Development Facilitation Team (DFT) – Review Comments

Project No: PR-2022-007103 Date: 07/10/2024 Agenda Item: #1 Zone Atlas Page: M-14

Request: Final EPC sign-off for Love's Sunport development, Loves Travel Center

Application For: SI-2024-00922 – EPC FINAL SIGN-OFF

**A-5**

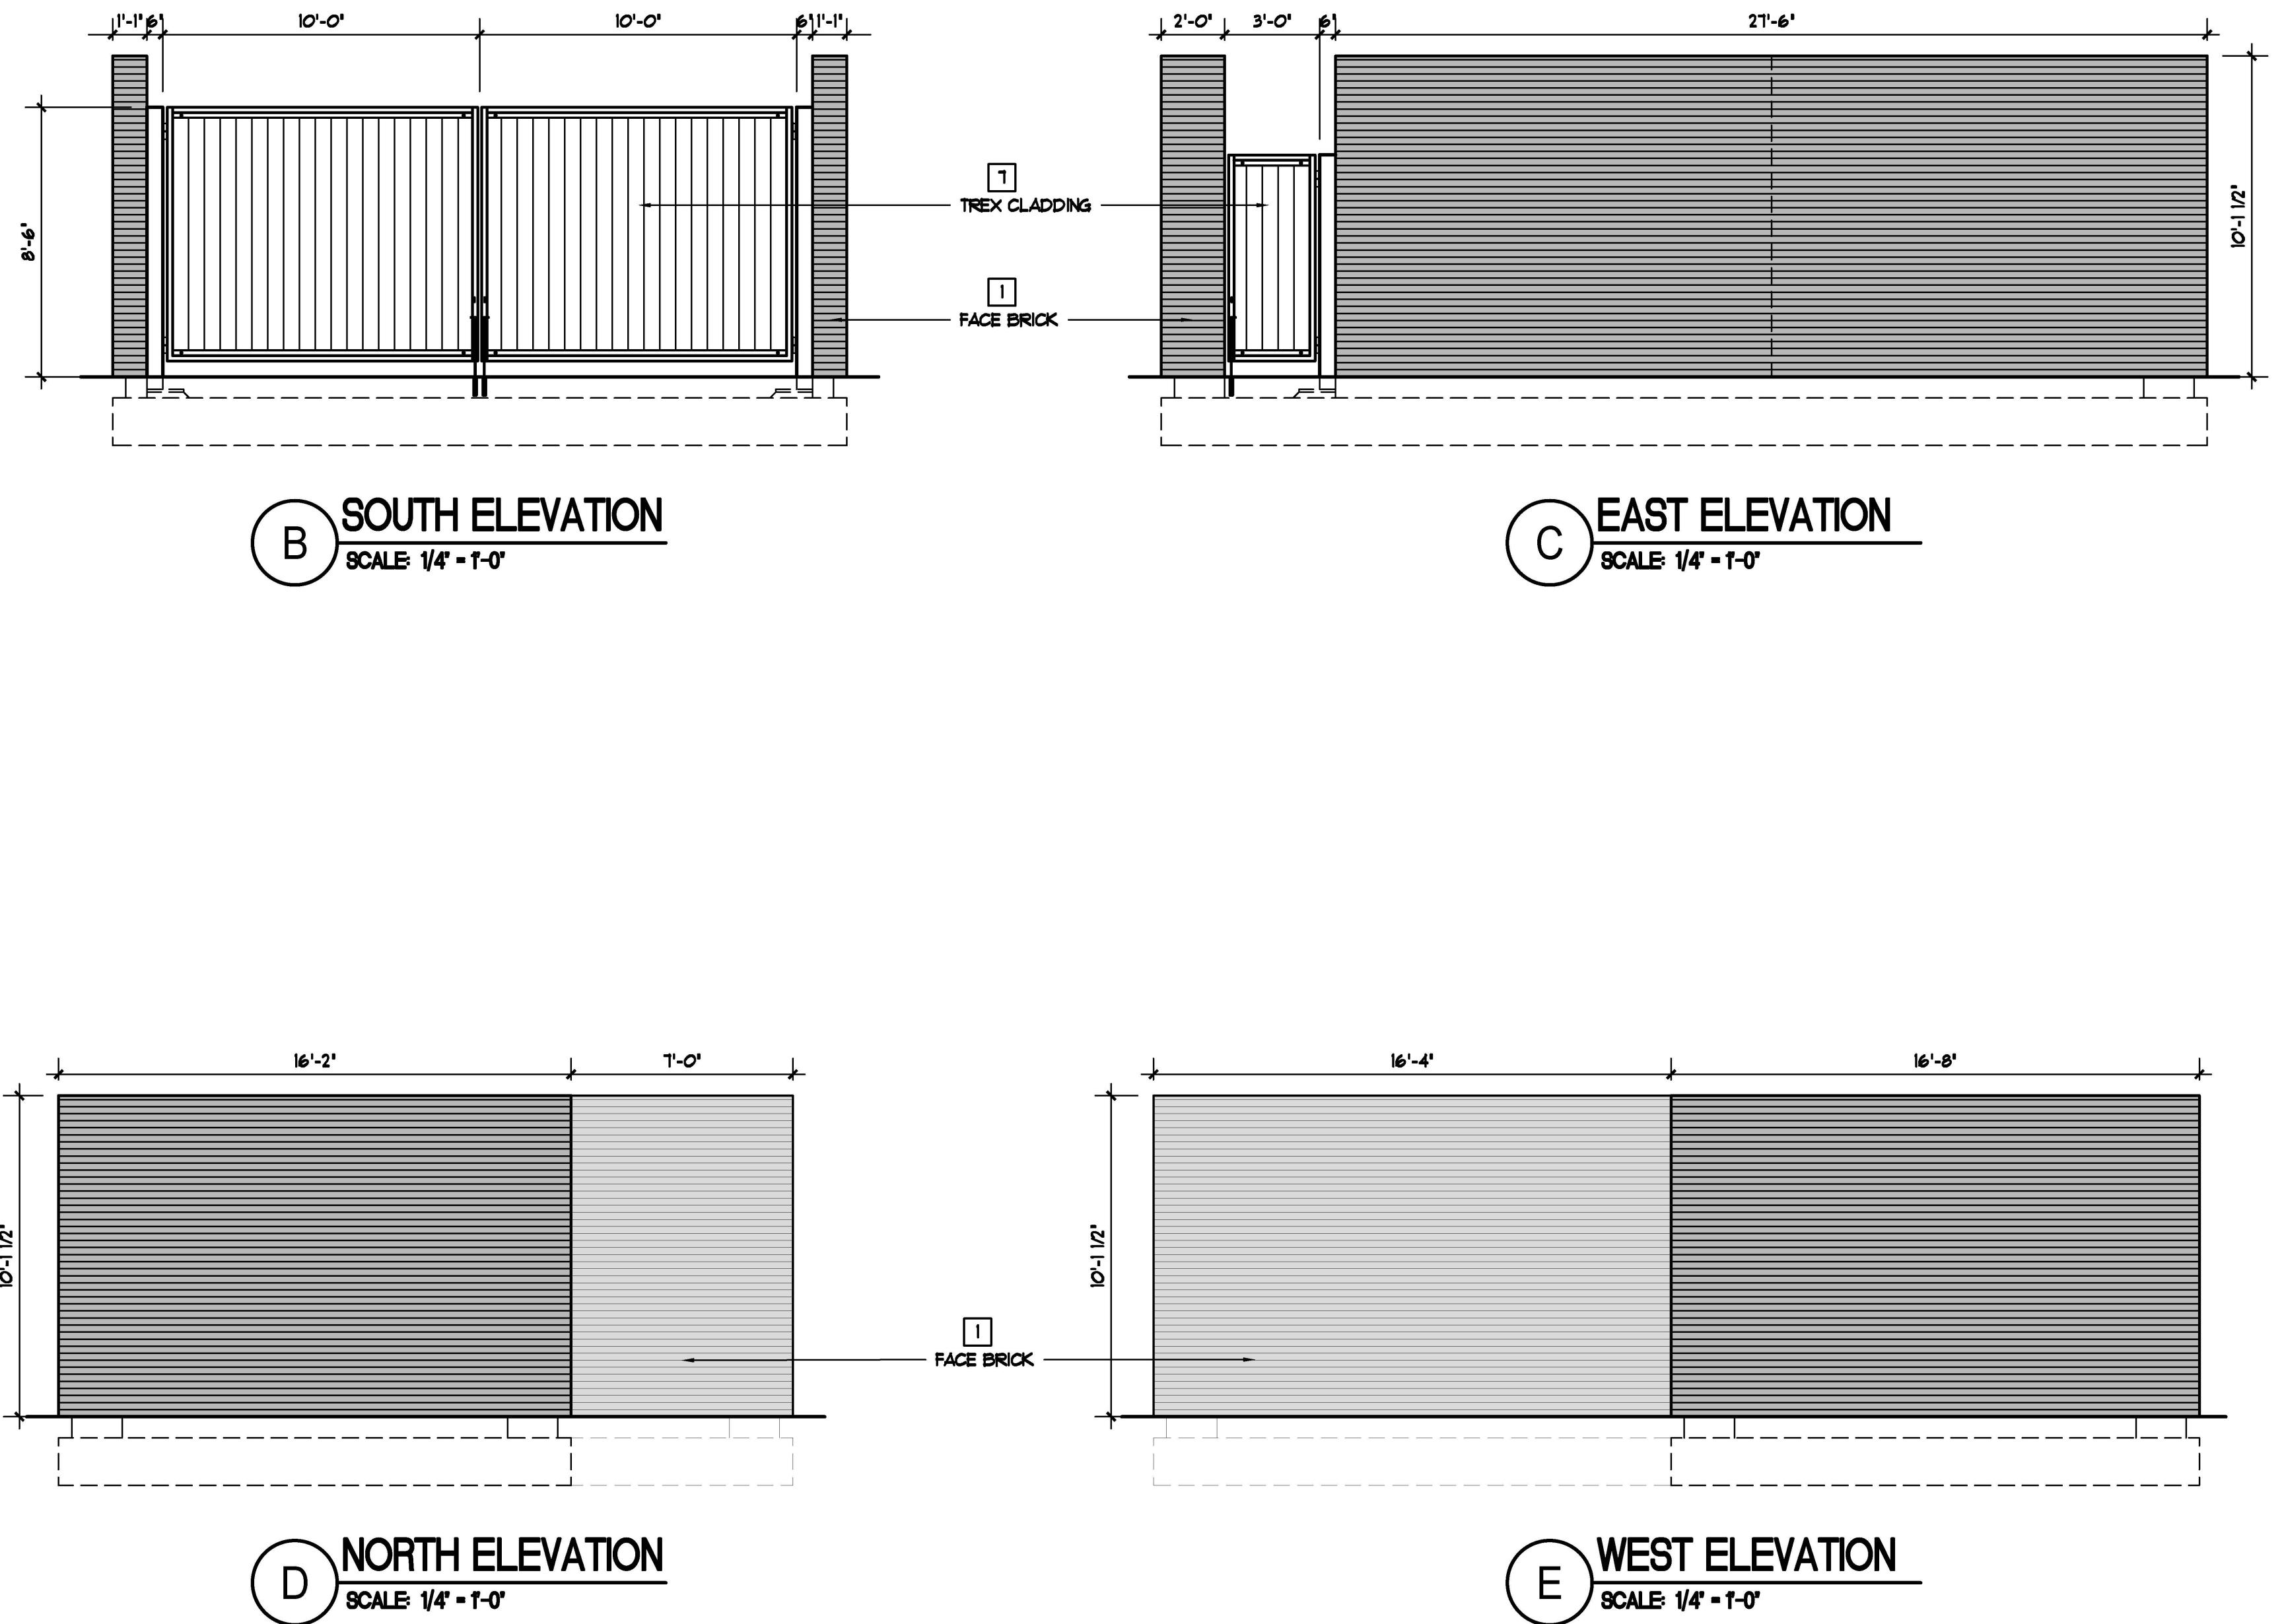
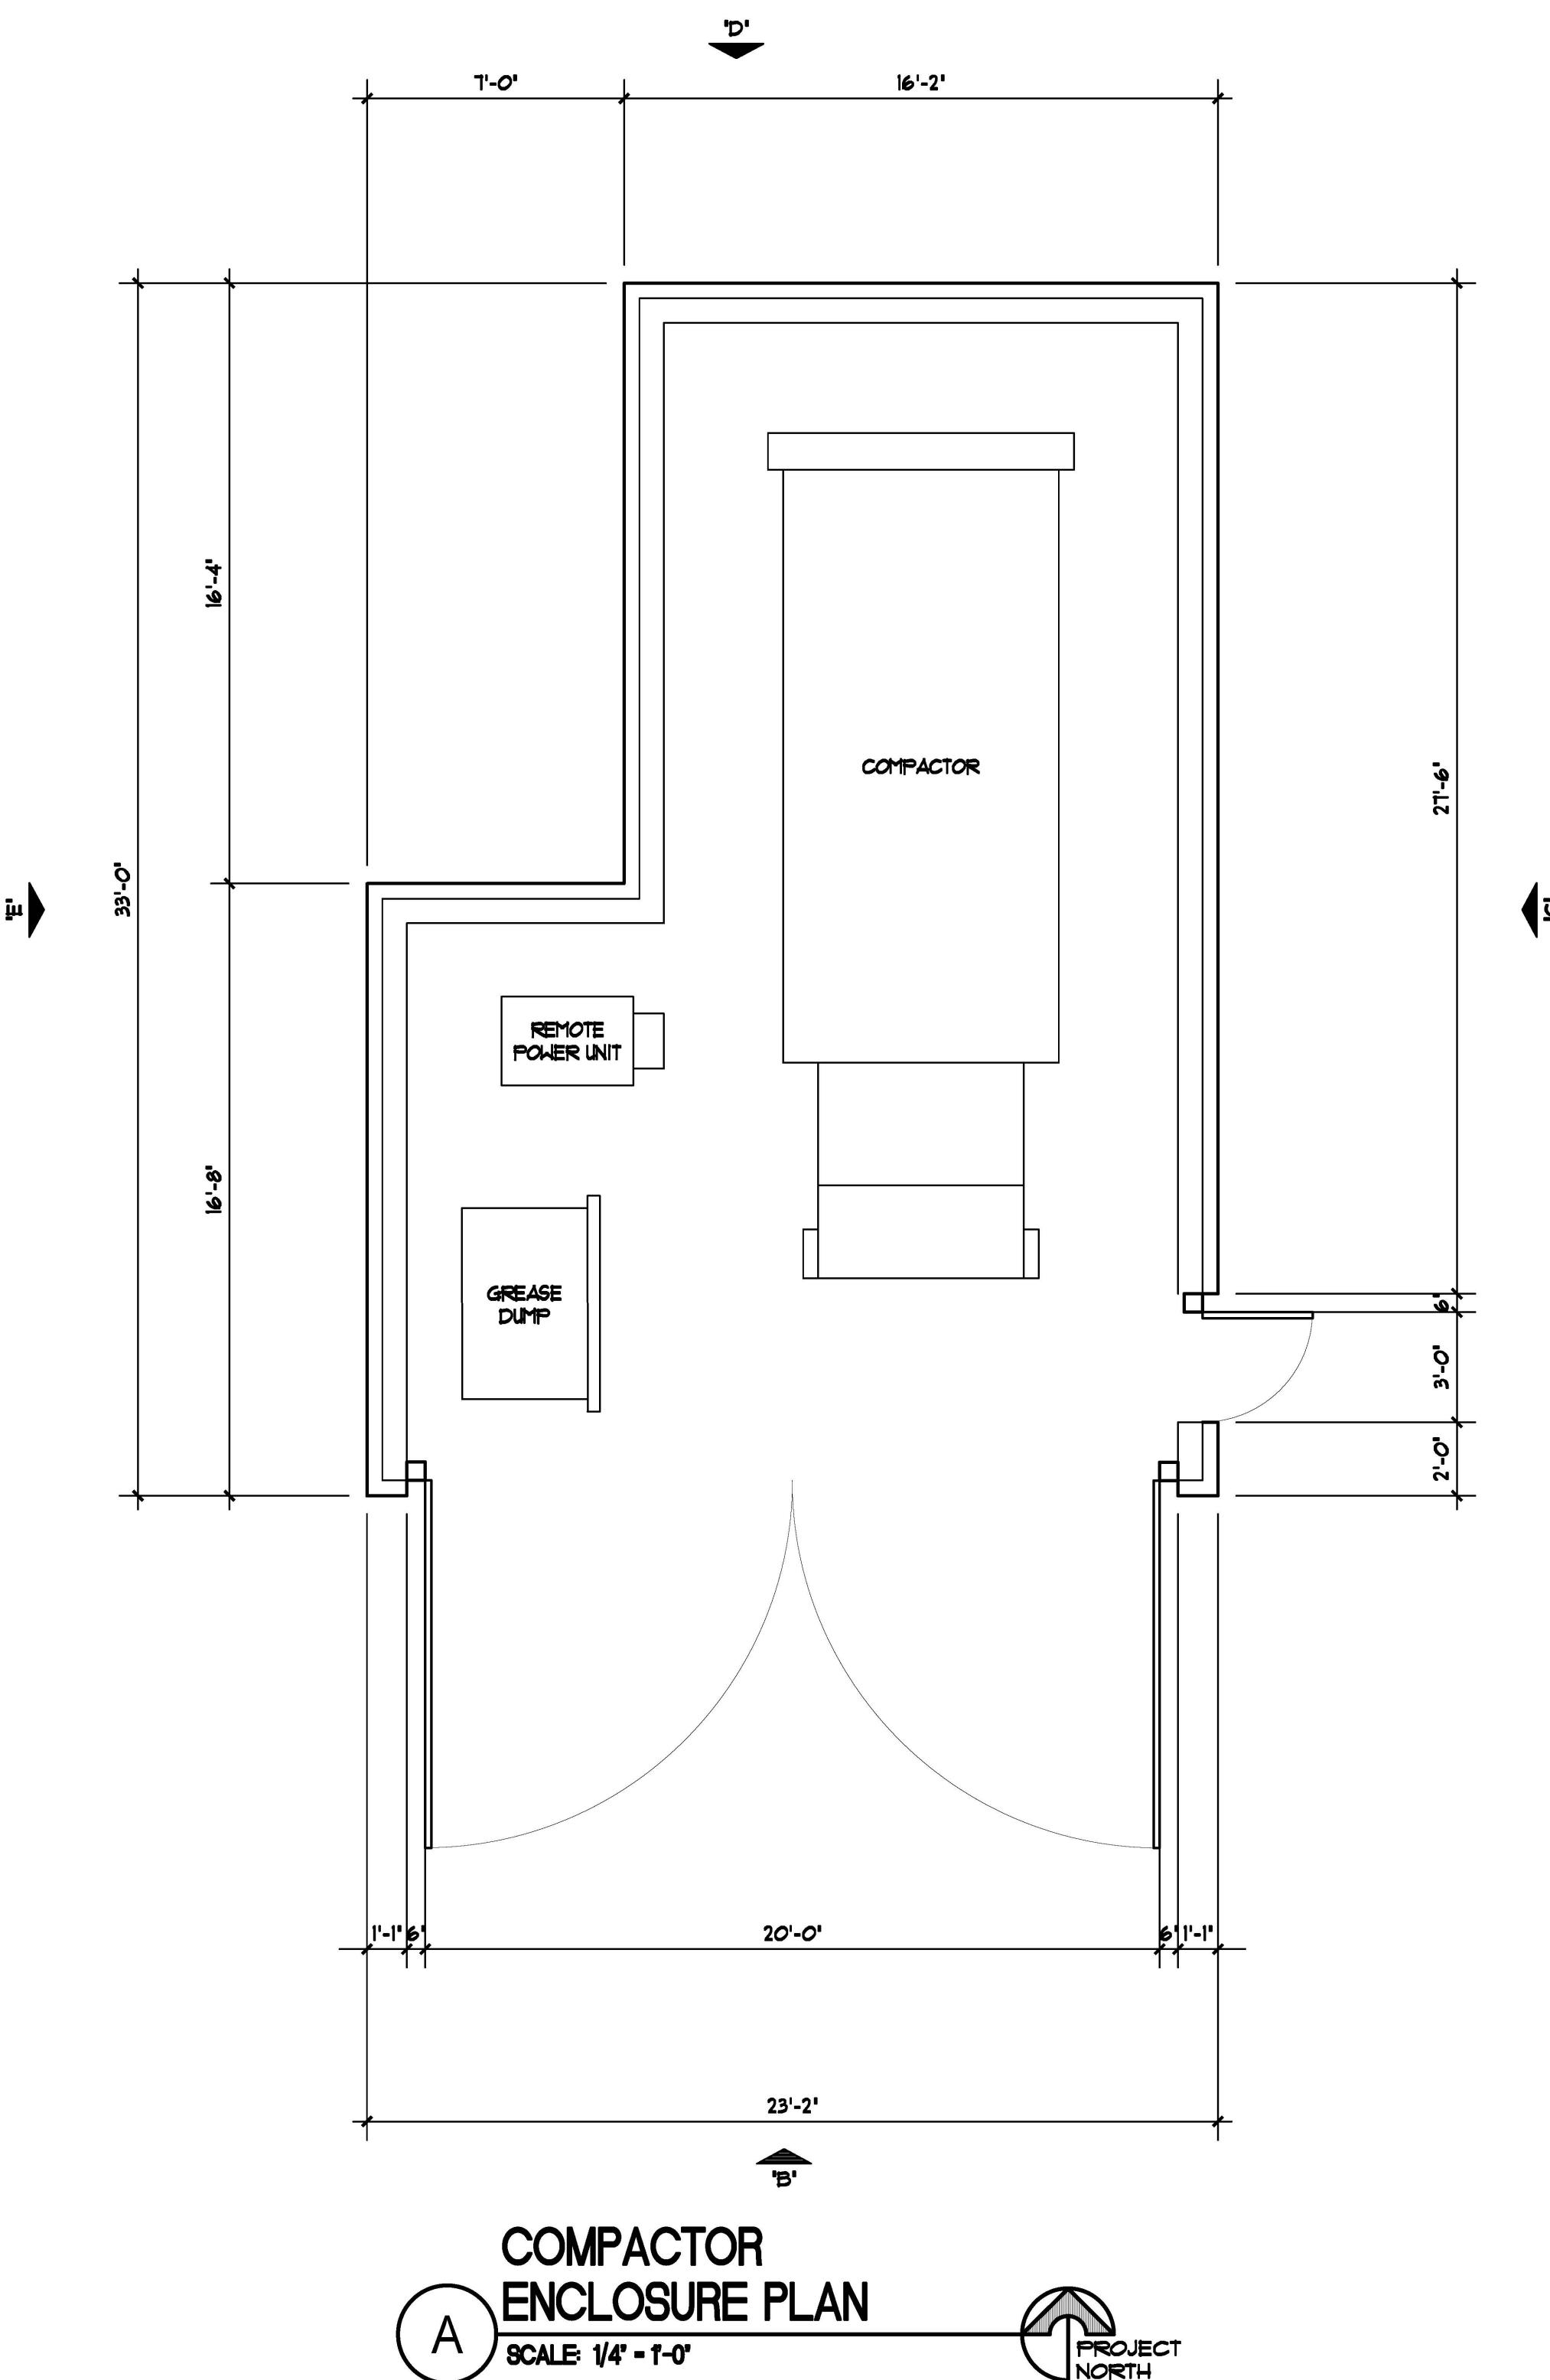
5. Lighting for fuel canopies: Need to add note on Sheet A-6, as per EPC Notice of Decision, indicating that the lighting in the canopies will meet requirements of IDO 4-3(D)(17)(d).

note added to sheet A-6
